Application for a Non-Material Amendment Following a Grant of Planning Permission

Construction of a head house and associated hard and soft landscaping and provision of a temporary access from Welling Way. (Re-consultation due to departure from the Development Plan

18/4264/F

The proposed design amendments for the Eltham headhouse are the outcome of progressive detailed design development of the Approved Design.

East West Site Section
1 : 200

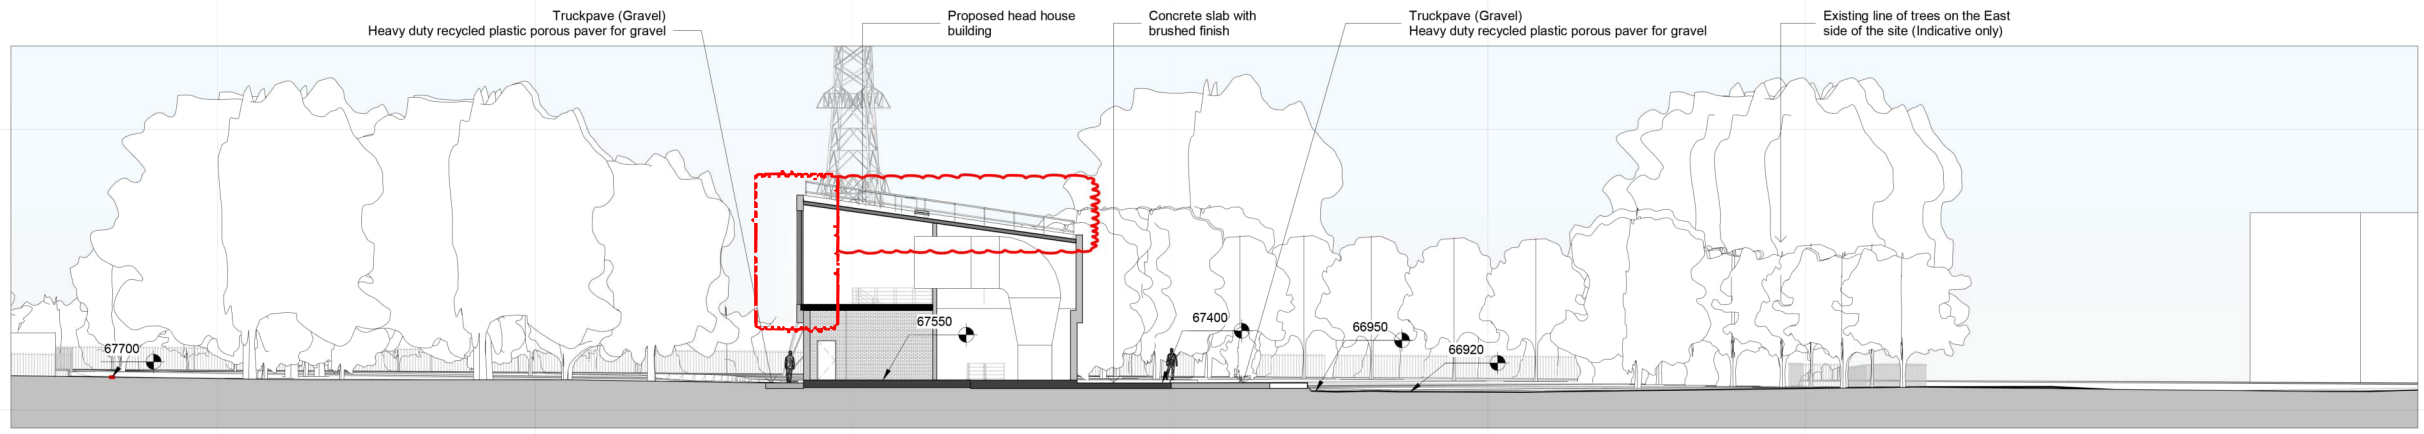
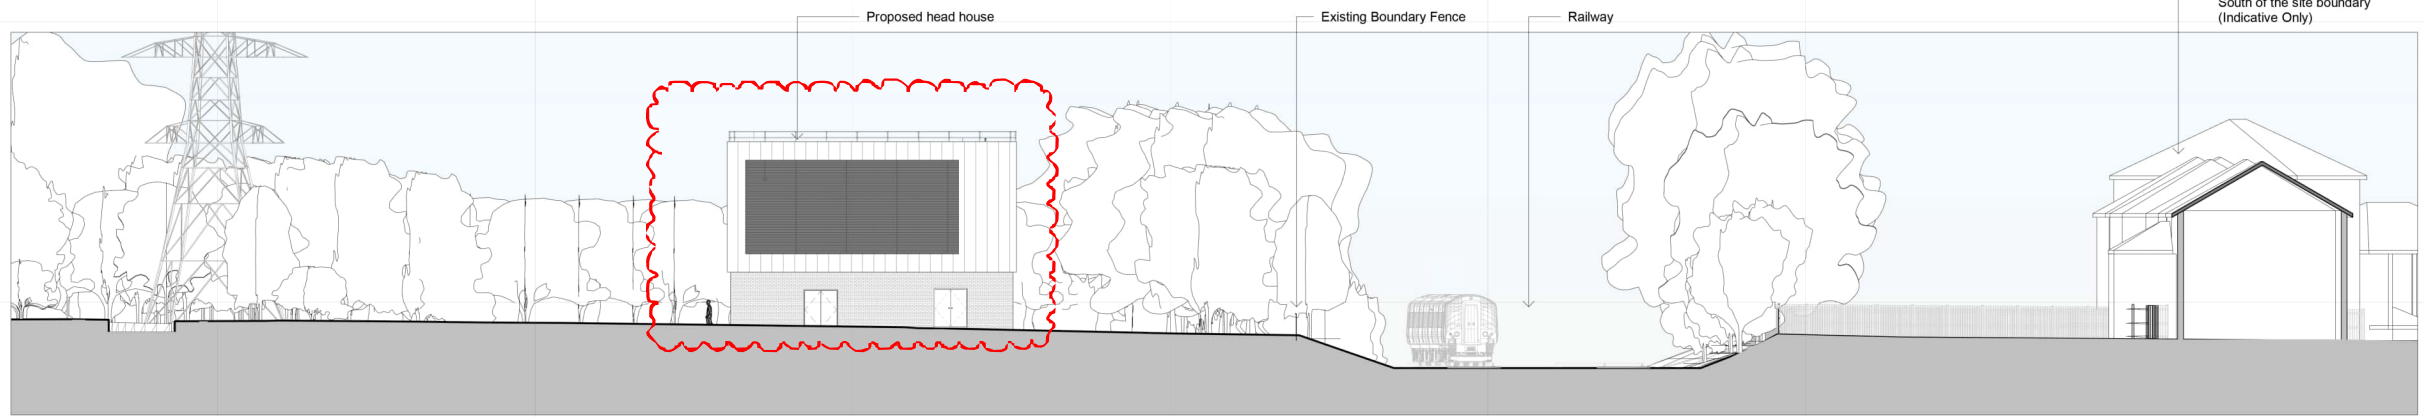
The technical design development of the mechanical ventilation systems has been resolved through the incorporation of specific equipment from manufacturers such that the overall size of the equipment (e.g. fans and ducts) has been slightly reduced compared to the spatial allowances provided in the Approved Design. Consequentially, the mezzanine level has been reduced in footprint, the external louvre area has been reduced and the East Elevation of the building (the lower side of the roof) has been slightly increased in height.

Taking into consideration the safety requirements under Construction Design and Management Regulations, in lieu of a fall-restraint system as indicated in the Approved Design, a balustrade around the perimeter of the roof has been introduced. Balustrading, a passive mitigation measure against the risk of falls at height, is appropriate in the context of the green roof design and its attendant access and maintenance requirements.

National Grid Document Number:
PDD-11524-ARC- 411
 FEED Document Number:

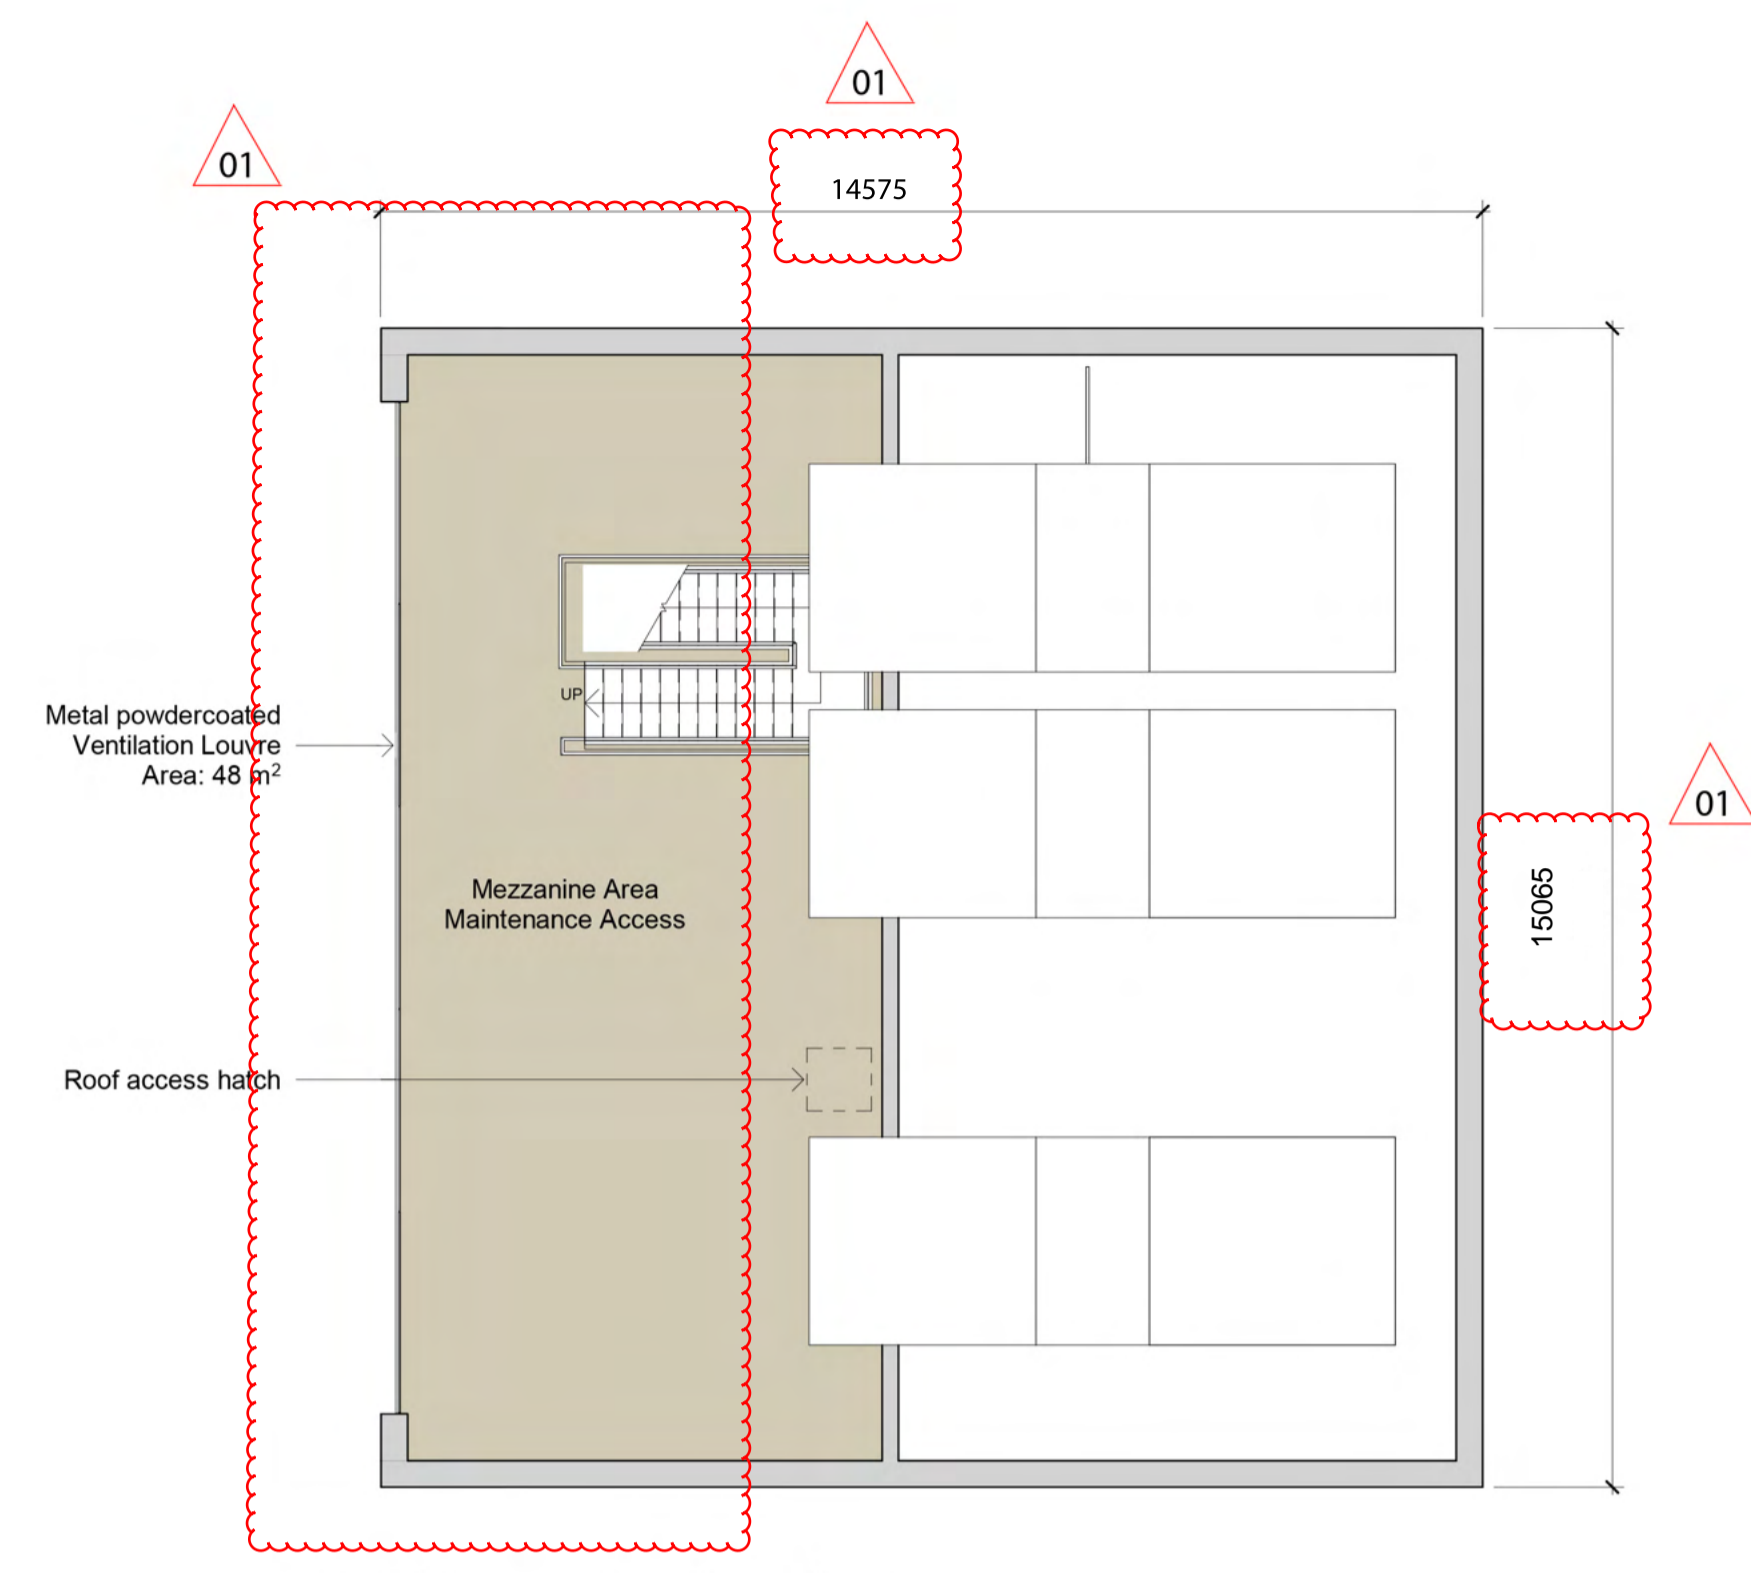
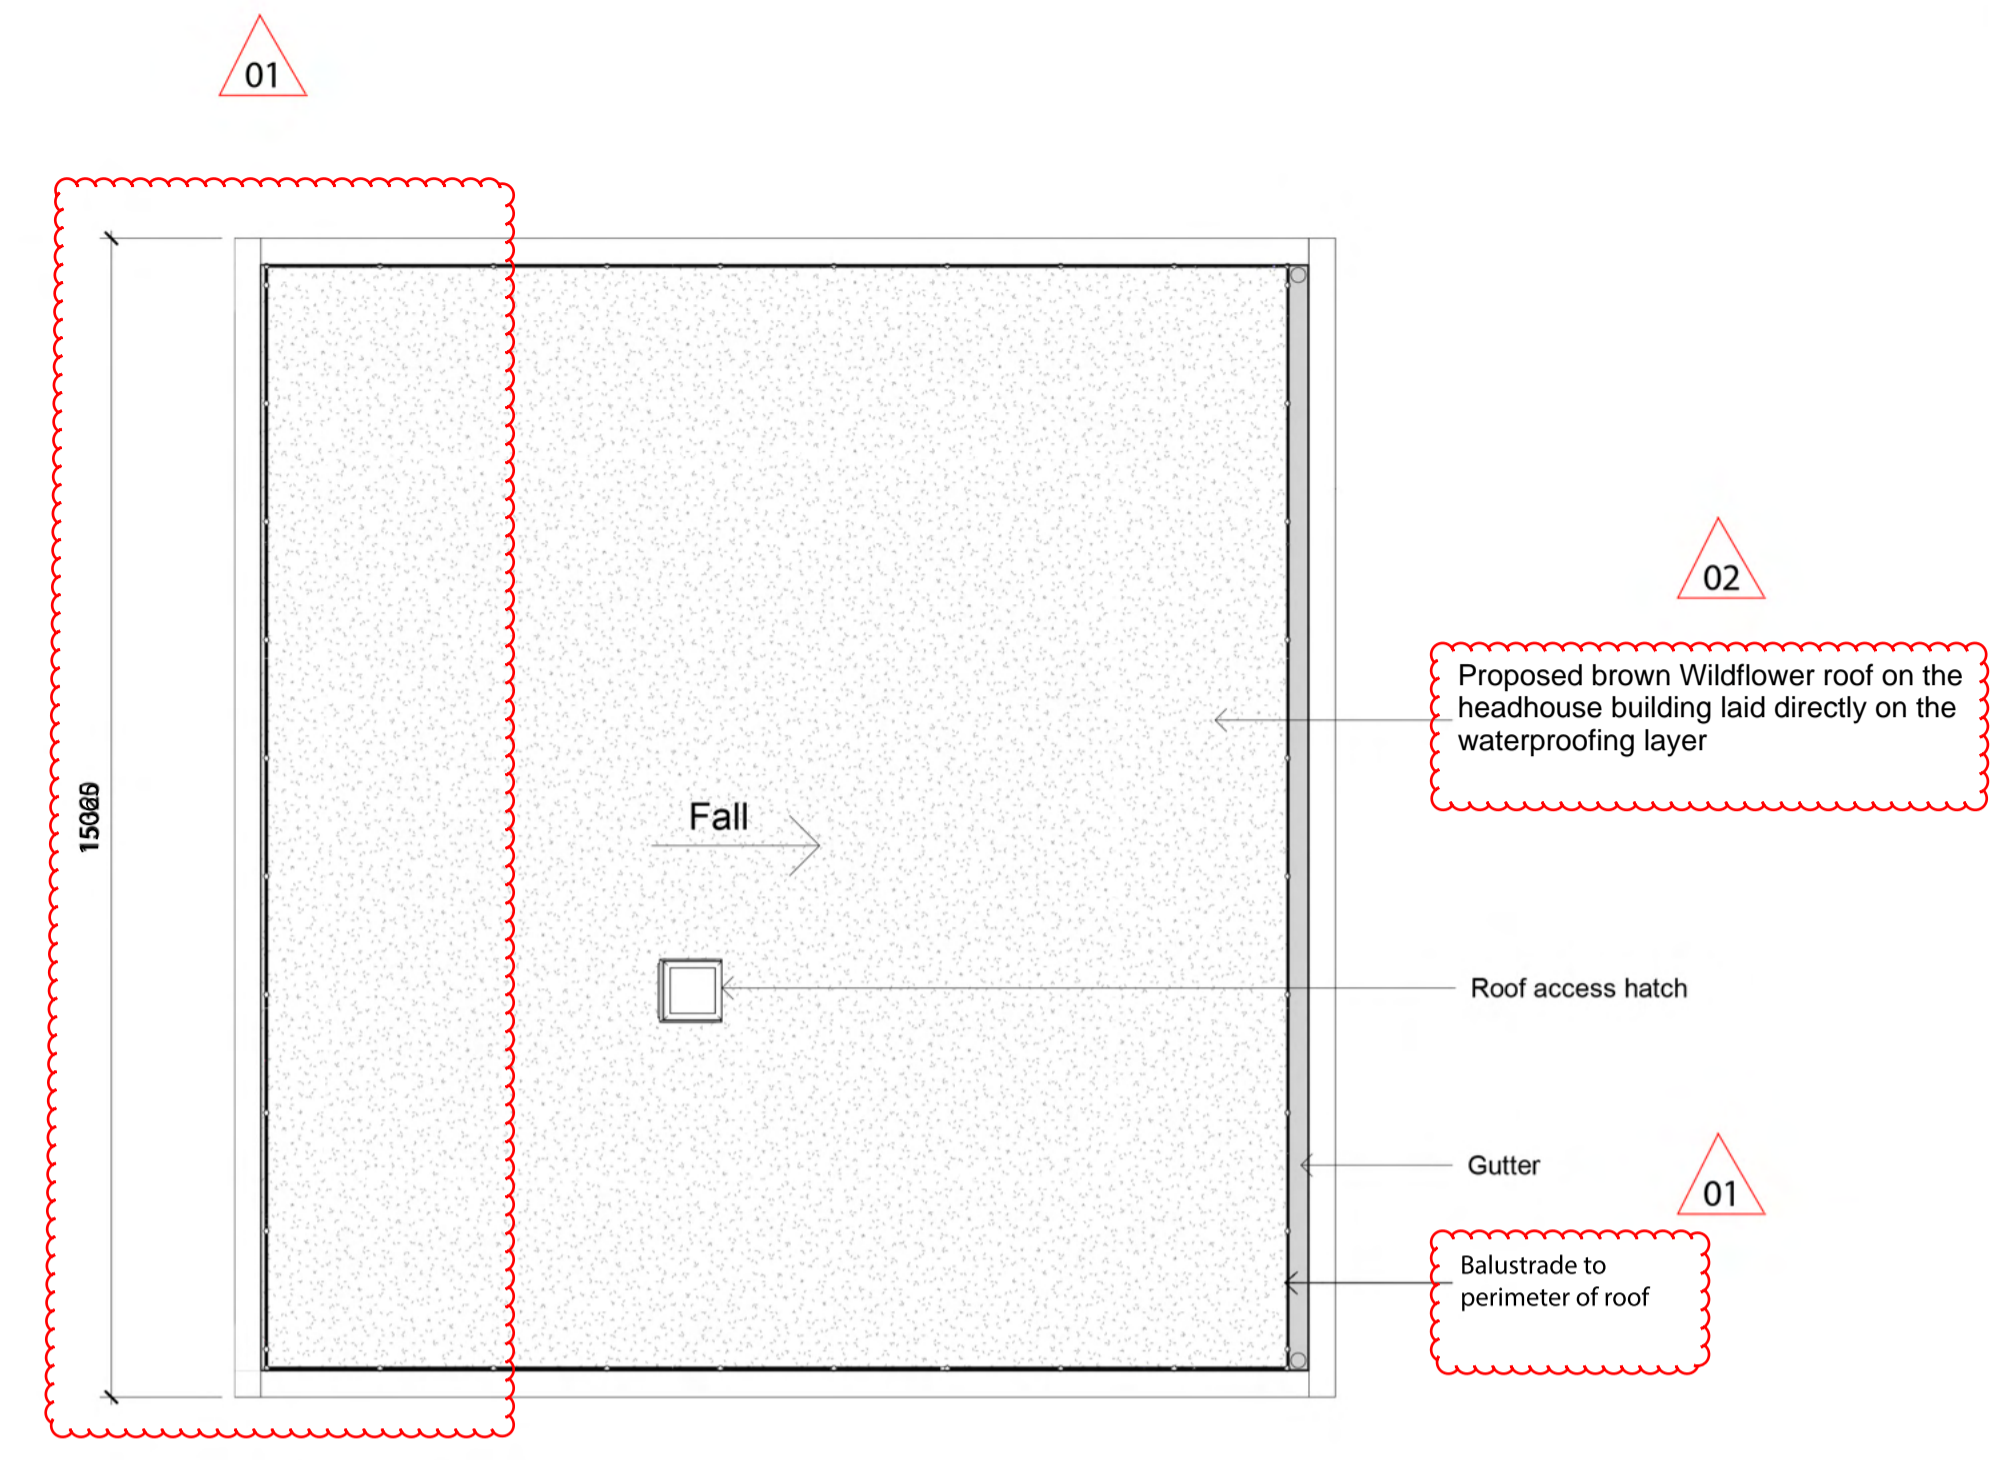
Closer integration of National Grid's functional requirements has resulted in the introduction of additional doors at ground level (on West and South Elevations).

The description of the Green roof on drawing PDD-11524-ARC- 403_02 has been clarified as a Brown Wildflower type, rather than Brown Wildflower/Sedum. This is in line with the approved Ecological Management Plan (LPT2-HMV-TUN-ELTH-PLN-EN-250004) that was included in the submission associated with Decision Notice 21/0531/SD and provides a significantly greater level of biodiversity compared to Sedum.
